From: Karen Garner
Sent: 26 March 2020 12:28
To: Tracey Headley-Smith
Subject: FW: AL/106/19/DOC
Attachments: Build Program 2021-2022.pdf; Build Program 2020-2021.pdf

From: Fiona Fitzgerald <Fiona.Fitzgerald@arun.gov.uk>
Sent: 24 March 2020 16:33
To: Planning.Responses <Planning.Responses@arun.gov.uk>
Cc: Karen Garner <Karen.Garner@arun.gov.uk>
Subject: AL/106/19/DOC

Further to my previous response to this application for Condition 7 (CMP), I asked for further detail on their complaint procedure in the CMP should there be a lighting complaint. They have just stated 'in the event of any queries or concerns the site manager is contactable'. Given that we have already had a lighting complaint about this site, I would appreciate it if they could expand more to advise of their complaint procedure in the event of a lighting complaint. I am satisfied with the noise part of the CMP, now they have put more detail into it.

REV. No.	DATE	DESCRIPTION	INITIALS
Client			
Project	Westergate & Eastergate		
Title	External Works Layout Sheet 1	Scale 1:250@A0 Checked AMc	Date Mar '18 Drawn KT
Drawing No.	5655:40	Rev	H

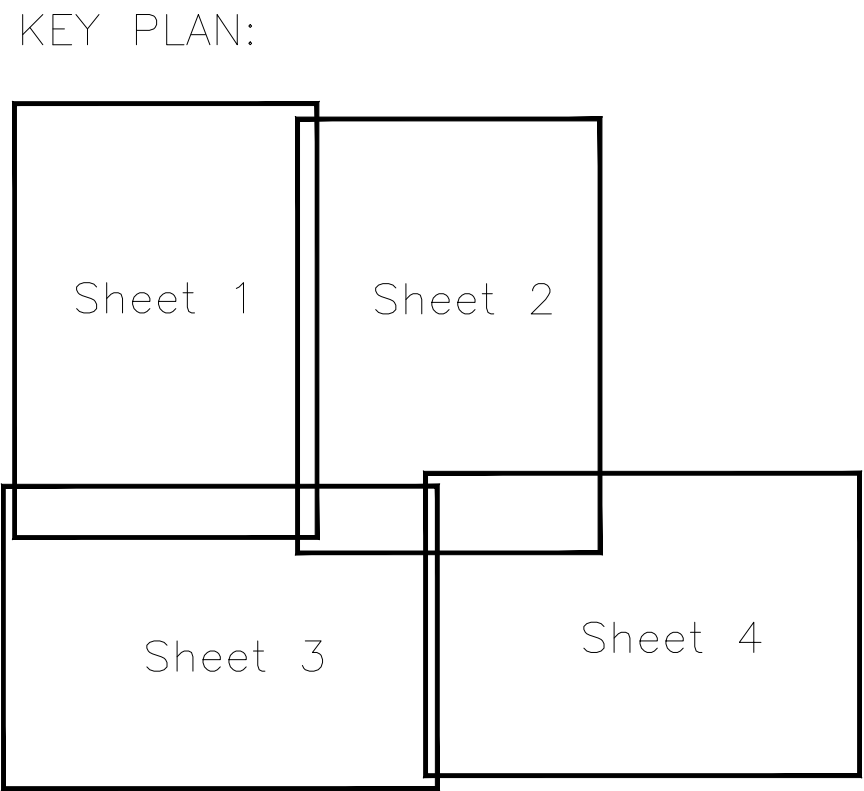
I haven't been able to find confirmation of the fact that the Lighting Schedule complies with Zone E2 of the ILP guidance – as discussed there are a couple of documents that the Planning Portal seems intent to keep me away from! If you could point me to the documentation that contains the Zone E2 confirmation I would be very grateful.
